Addendum

No. 1

Description: Revise front line beverage casework to accept cart. Separate eyewash from handsink per Code review comments.

Project Title Sheetz C-Store
Sawyer Road
Cameron, NC

SANITARY & VENT PIPING ISOMETRIC
NOT TO SCALE

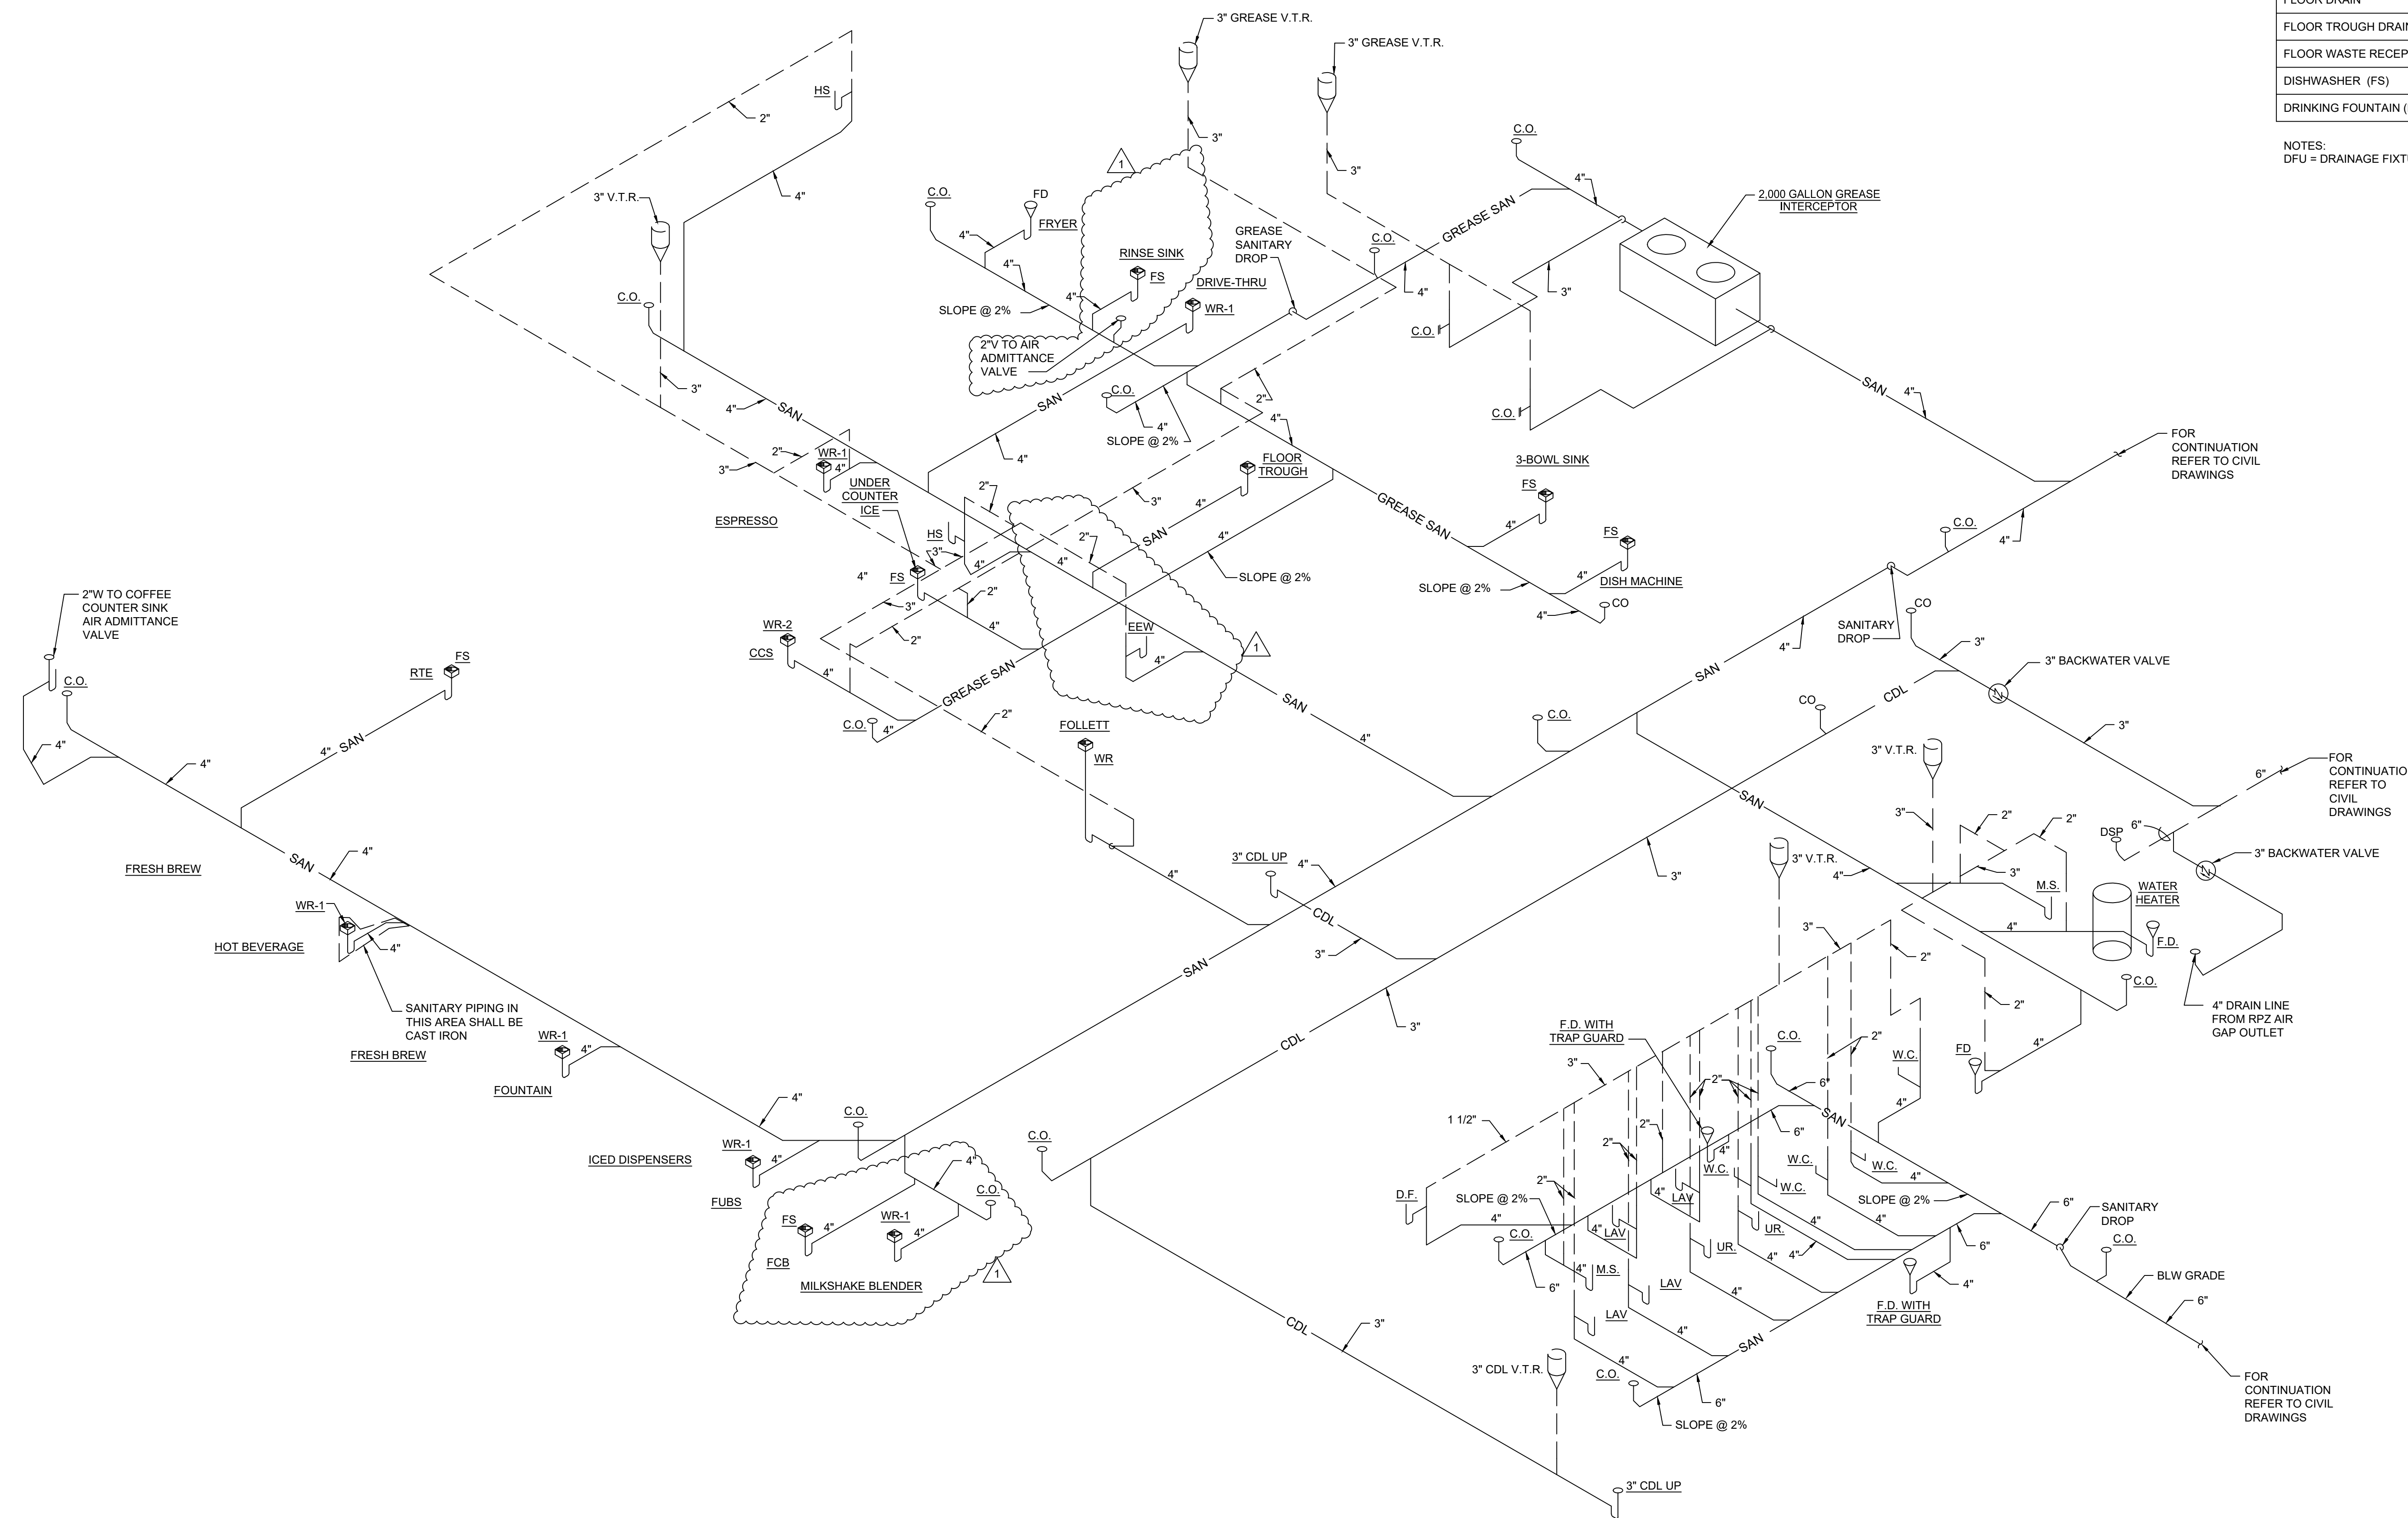
3. REMOVED 2"V-up and replaced with 2"W to air admittance valve at drive-thru.
4. ADDED eyewash sanitary and vent connections.

E301

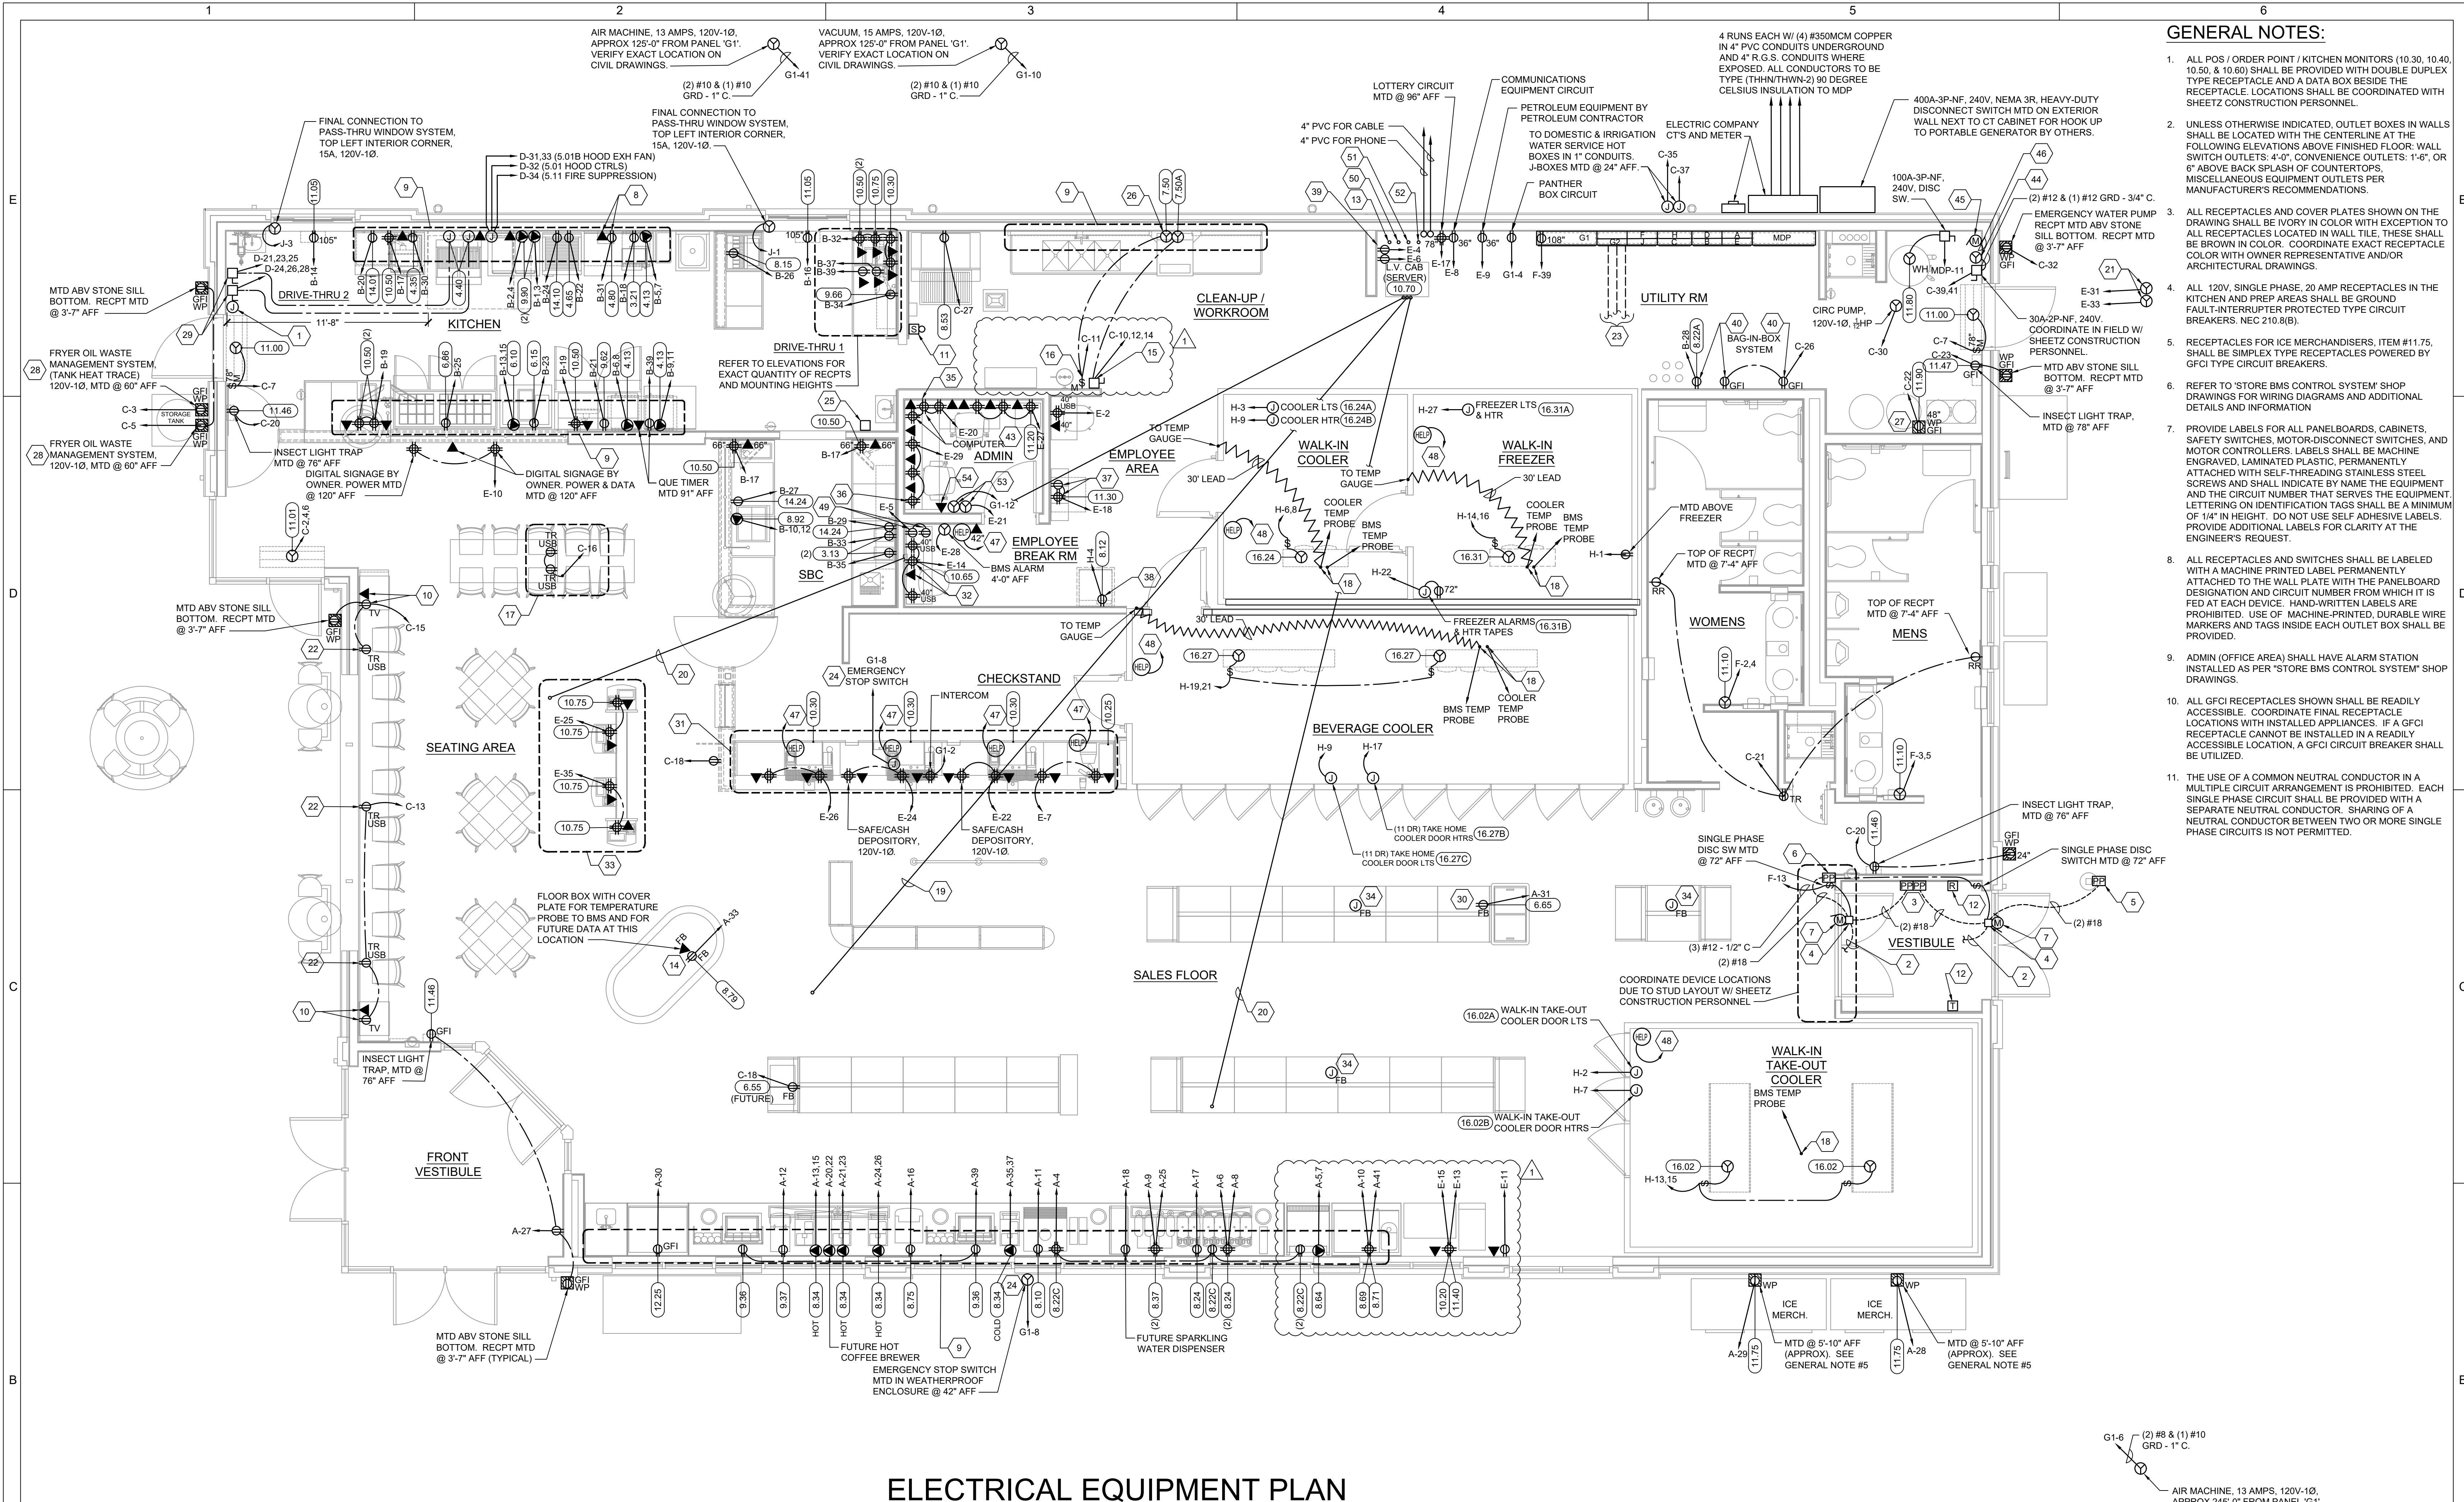
1. REVISED location of receptacles and data outlet for Monitor (#10.50) from 84" AFF to 70" AFF in Elevation #1.
2. ADDED conduit sizes to data outlets in Elevations #1.

3. NOTED data outlet to Monitor to read, "MTO TECH 104" in Elevation #1.
4. REVISED location of receptacles and data outlet for Register (#10.30) from 20" AFF to 46" AFF in Elevation #2.

5. REVISED location of receptacles and data outlet for Monitor (#10.50) to be centered on wall between Monitor and walkthrough opening at 79" AFF in Elevation #2.

6. ADDED conduit sizes to data outlets in Elevations #2
7. ADDED note to data outlet for Queue Timer 1 in Elevation #2
8. ADDED note "MTO TECH 107" to Elevation #2.

9. ADDED note "NODE 49" to Elevation #2.
10. ADDED note "POS 4" to Elevation #2.
11. ADDED note "MX915-4" to Elevation #2
12. ADDED note "G5 BASE STATION" to Elevation #2

13. ADDED note "MTO TECH 106 COLD COFFEE" to Elevation #2.
14. ADDED note to data outlet for Queue Timer in Elevation #3
15. ADDED conduit sizes to data outlets in Elevations #3

16. ADDED note "MTO TECH 101" to Elevation #3
17. ADDED note "MTO TECH 102" to Elevation #3
18. ADDED note "MTO TECH 105" to Elevation #3
19. ADDED note "MTO TECH 103 HOT COFFEE" to Elevation #4

20. ADDED conduit sizes to data outlets in Elevations #4
21. ADDED conduit sizes to data outlets in Elevations #5
22. REVISED location of receptacles and data outlets to accommodate the architectural addition of the FCB Dispenser rolling cart to beverage line area in Elevation #5.

23. REVISED mounting height to receptacles of Item #9.36 to 18" AFF
24. REVISED mounting height of receptacle of Item #8.64 to 18" AFF
